**Benjamin Wallace - Re: Code waivers for 91 State Street**

**From:** John Anton  
**To:** Wallace, Benjamin; Andrews, Deb  
**Date:** 6/10/2013 4:58 PM  
**Subject:** Re: Code waivers for 91 State Street  
**CC:** Levine, Jeff

RE: 91 STATE STREET APARTMENTS

2 PROPOSED FIRST FLOOR PLAN - 3,386 GROSS SQ.FT.
 SCALE: 1/8"=1'-0"

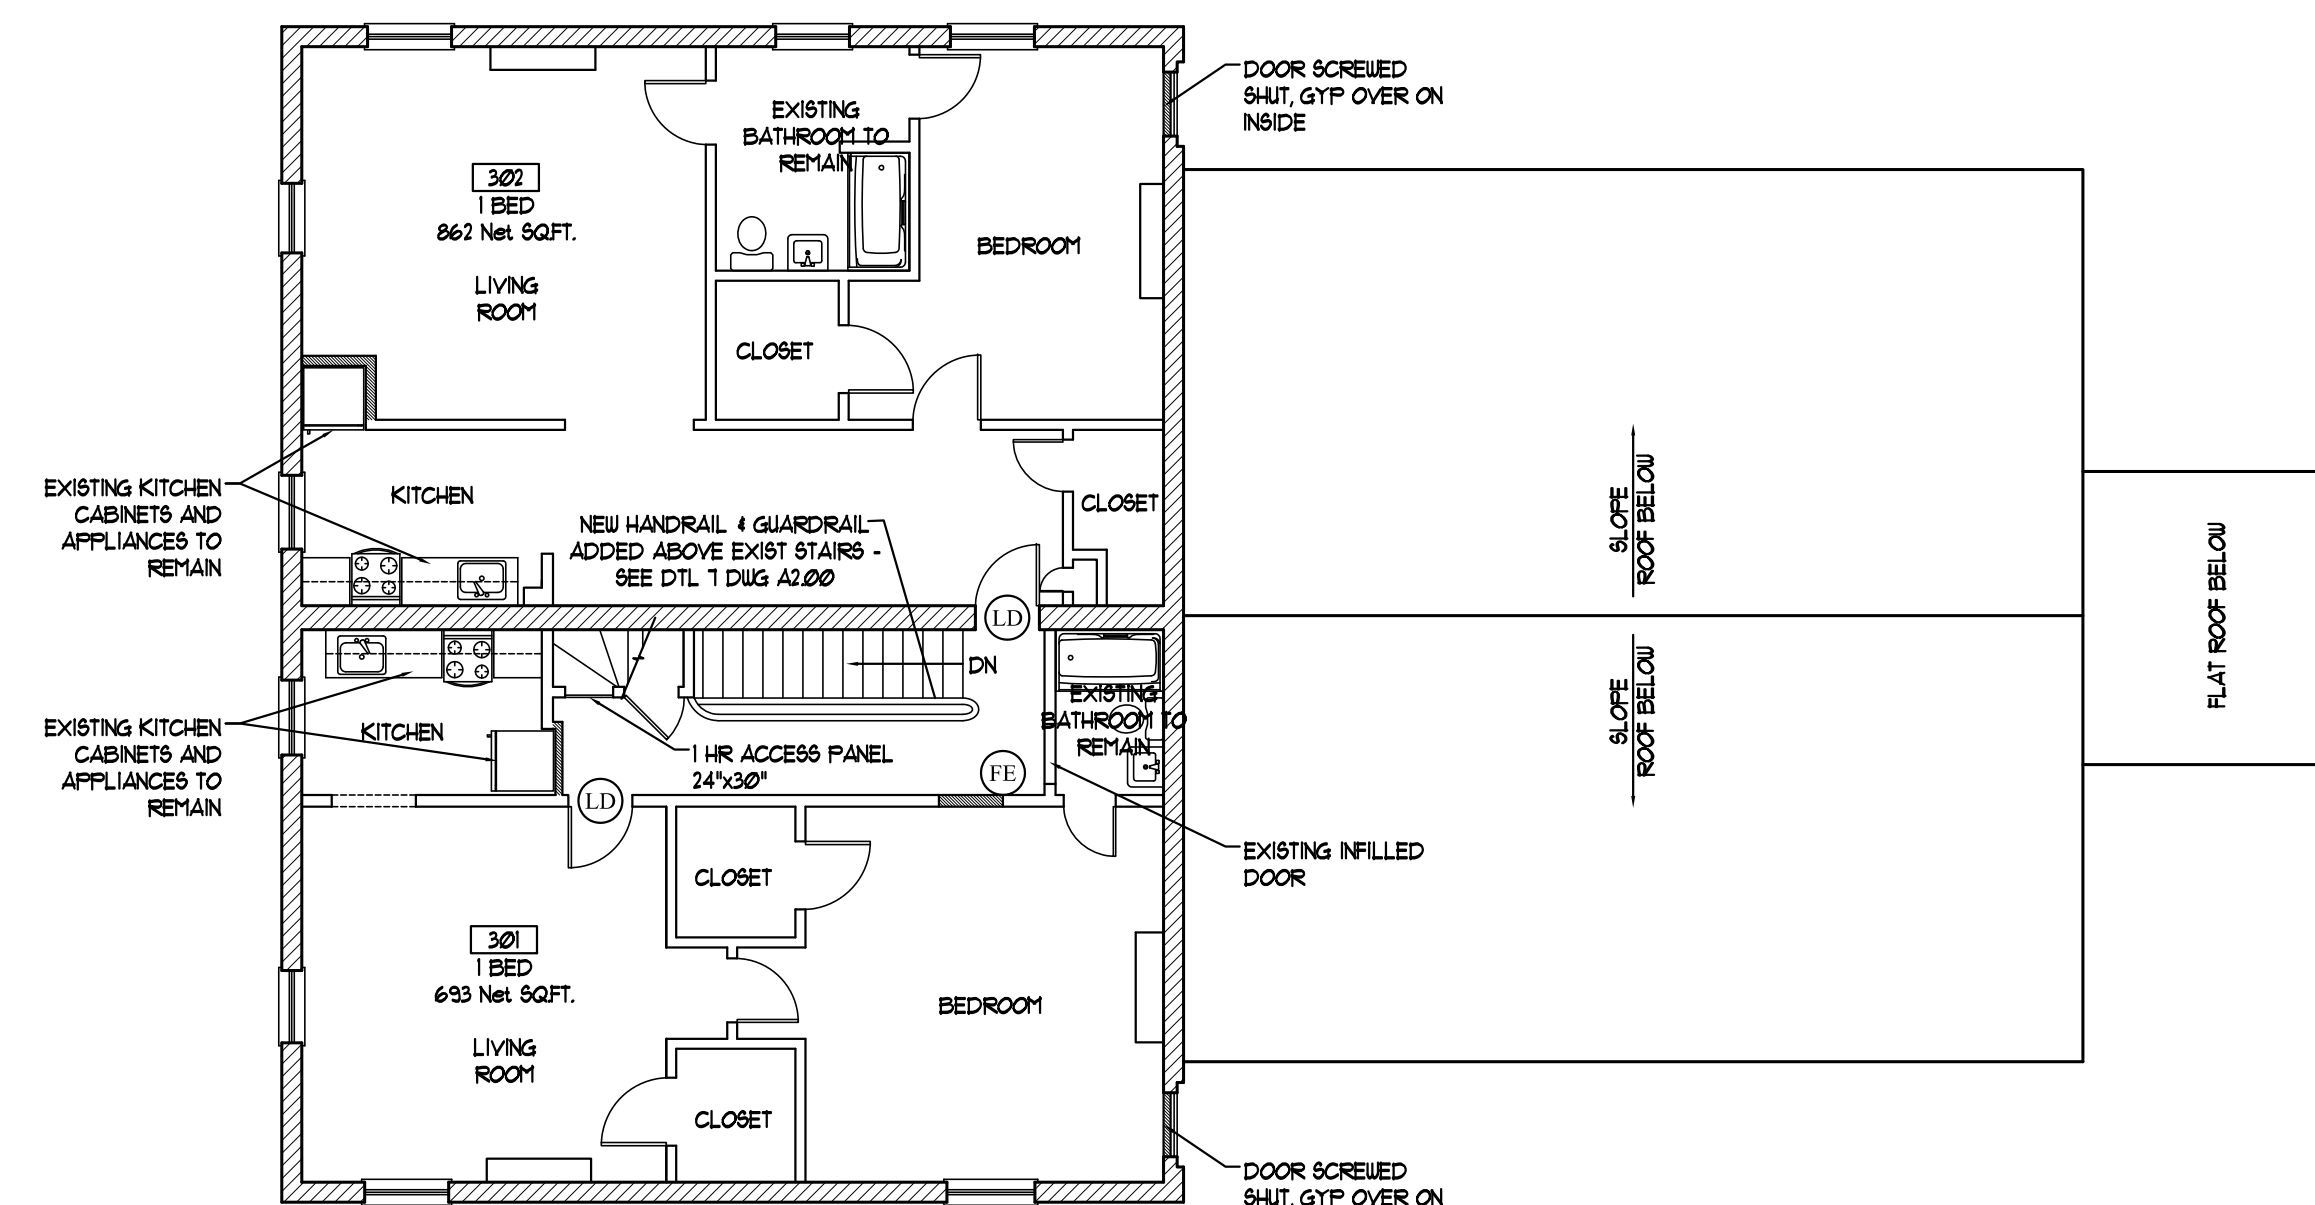
1. The guards for the new outside stairs serving Units 103 and 104 are only 36 inches high rather than 42 inches as required by NFPA 101:7.2.2.4.5.2;
2. A handrail is being provided on one side of the new stairs serving Units 103 and 104 rather than both sides of the stair as required by NFPA 101:7.2.2.4.1.1; and
3. The interior existing stair handrails are 26 inches above the leading edge of the treads rather than 30 - 38 inches above the leading edge of the treads as required by NFPA 101:7.2.2.4.4.2.

I have reviewed the plans for exterior and interior stairs at 91 State Street and support the applicant's request for waivers of standard railing height requirements based on the building's historic designation. The waivers are requested in order to preserve original features and maintain traditional railing heights for new railings. Regarding the interior railings, it should be noted that this office has no review authority over interior work. For the record, however, I support any effort to preserve important character-defining interior features where there is no obvious public safety hazard. I also understand that the applicant is seeking historic tax credits for the project and as such may need to retain original features to satisfy the requirements of that program.
